26 July 2021

Pre-application Advice

MONKS HALL, SYLEHAM, SUFFOLK

DRAWING
 Existing Second Floor Plan

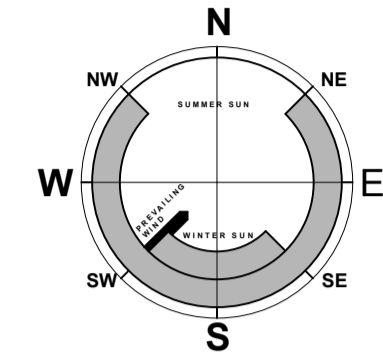
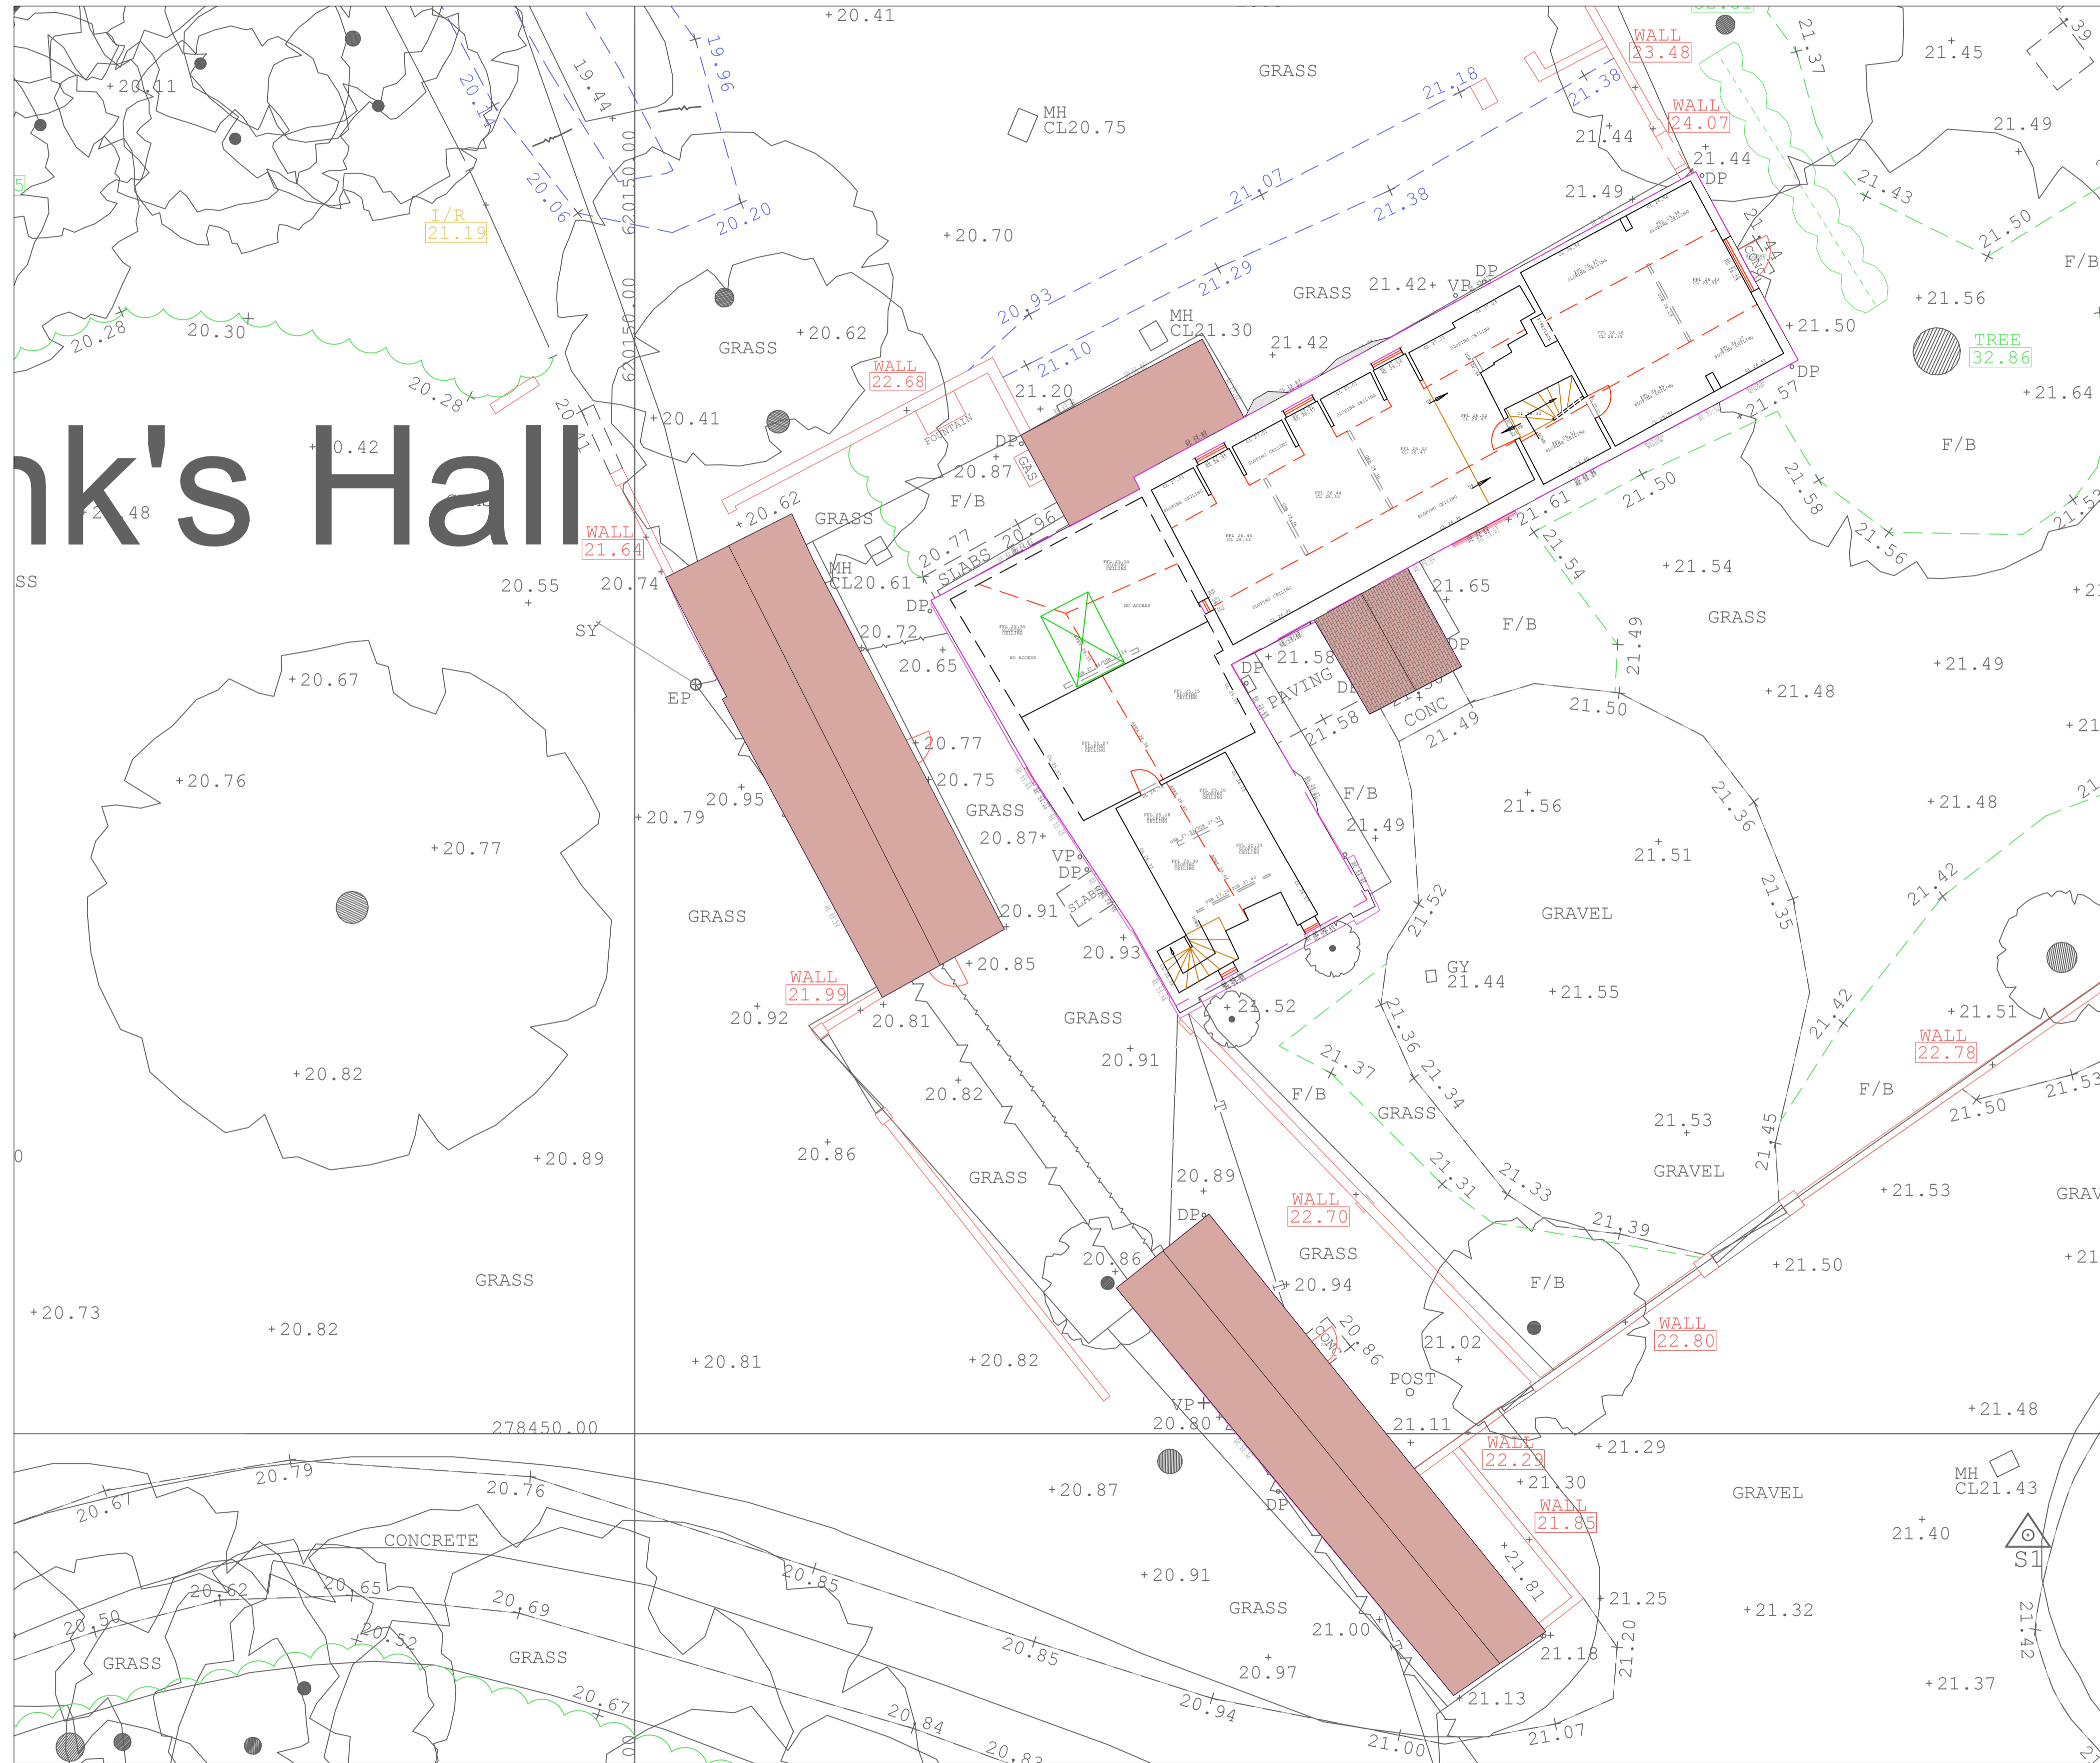
- Insertion of a bathroom on the second floor

This was discussed at length on site and we had concerns relating to extraction, impact of moisture upon the timber frame and the running of service pipes and external soil pipes. Insulation and breather membranes were also considered at length. Historic England would not wish to see any increase in the height of the roof and therefore insulation would need to be inserted between the rafters. This should be breathable insulation and breathable membranes should be used. There is no evidence of lathe and plaster within this room although it is clear that this would historically of been the case. It was suggested that a breathable board such as that available from The Lime Centre and others could be used as an alternative and Historic England would not object to this in this instance.

A full structural survey should be carried out that indicates that the floor is able to take this extra load and what additional support may be required if any. Should it become apparent that additional support is required then this should be brought to our

FIRST FLOOR PLAN

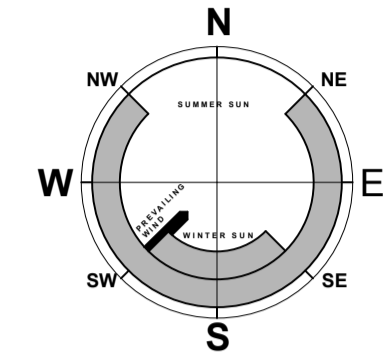
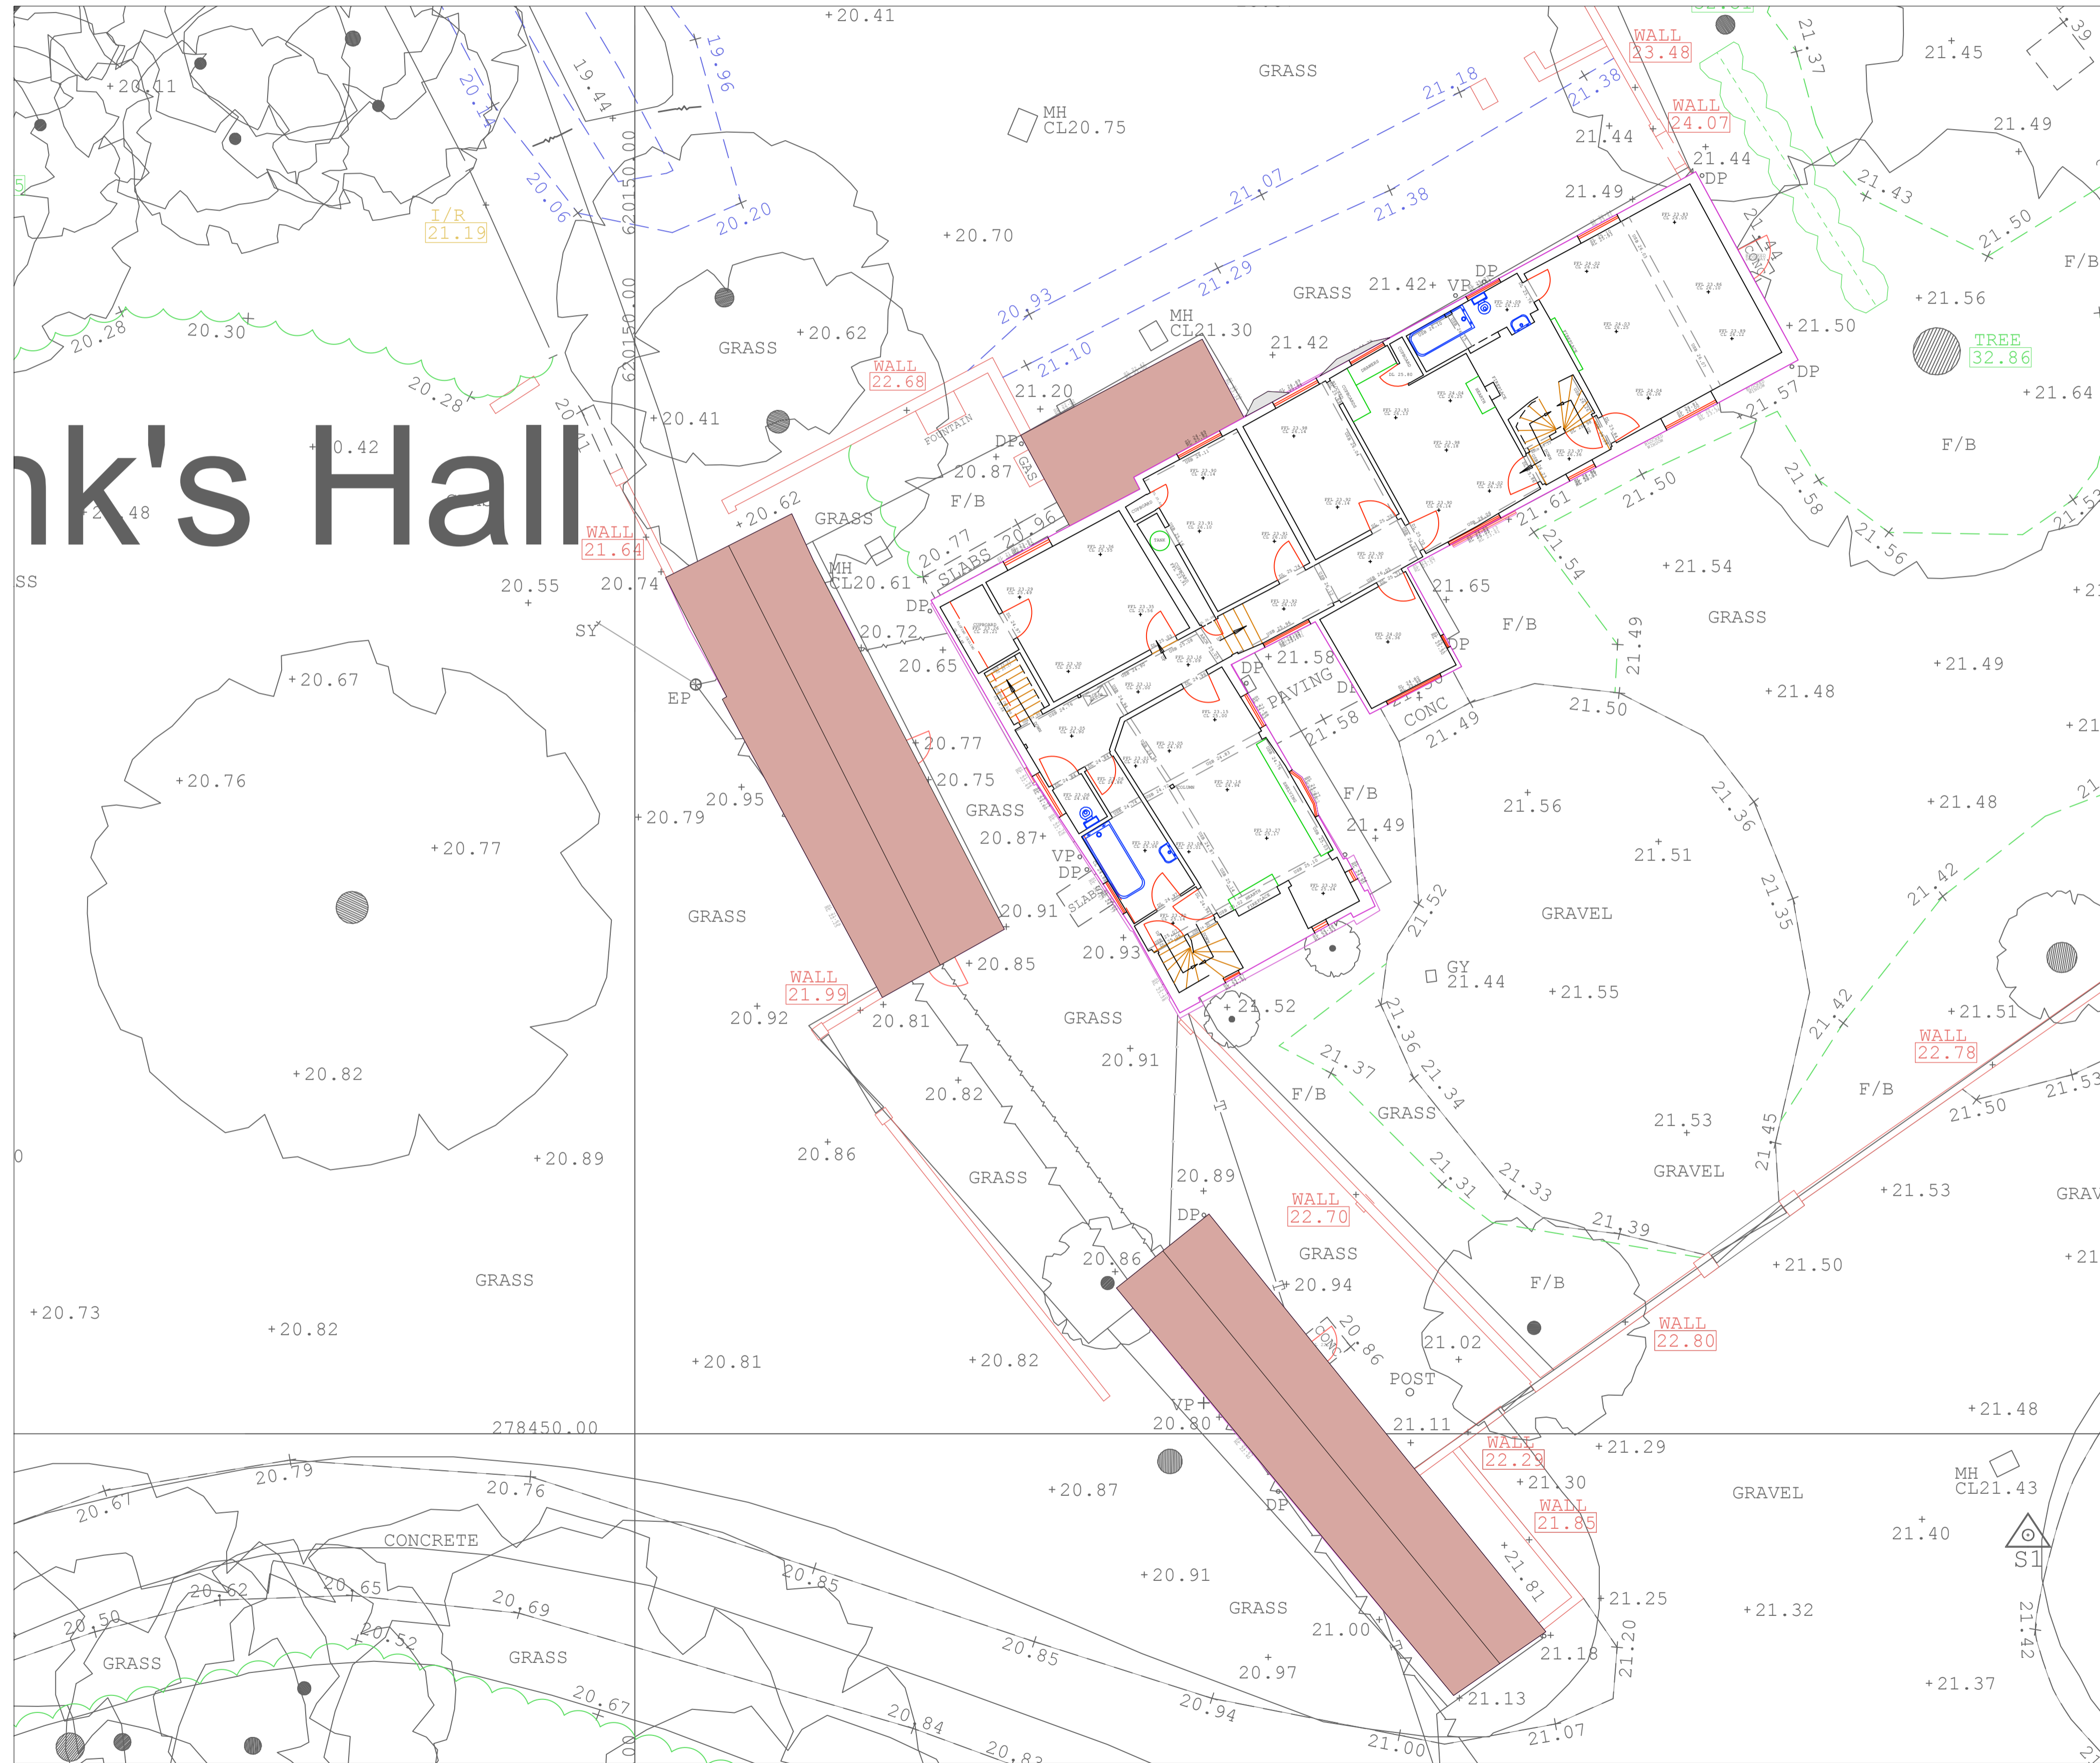
- Removal of partitions on the first floor

From our site visit it was clear that the partitions within the proposed master bedroom are modern plasterboard. It would be advantageous to the significance of the building to remove them. The en-suite bathroom lies in the position of an existing bathroom.
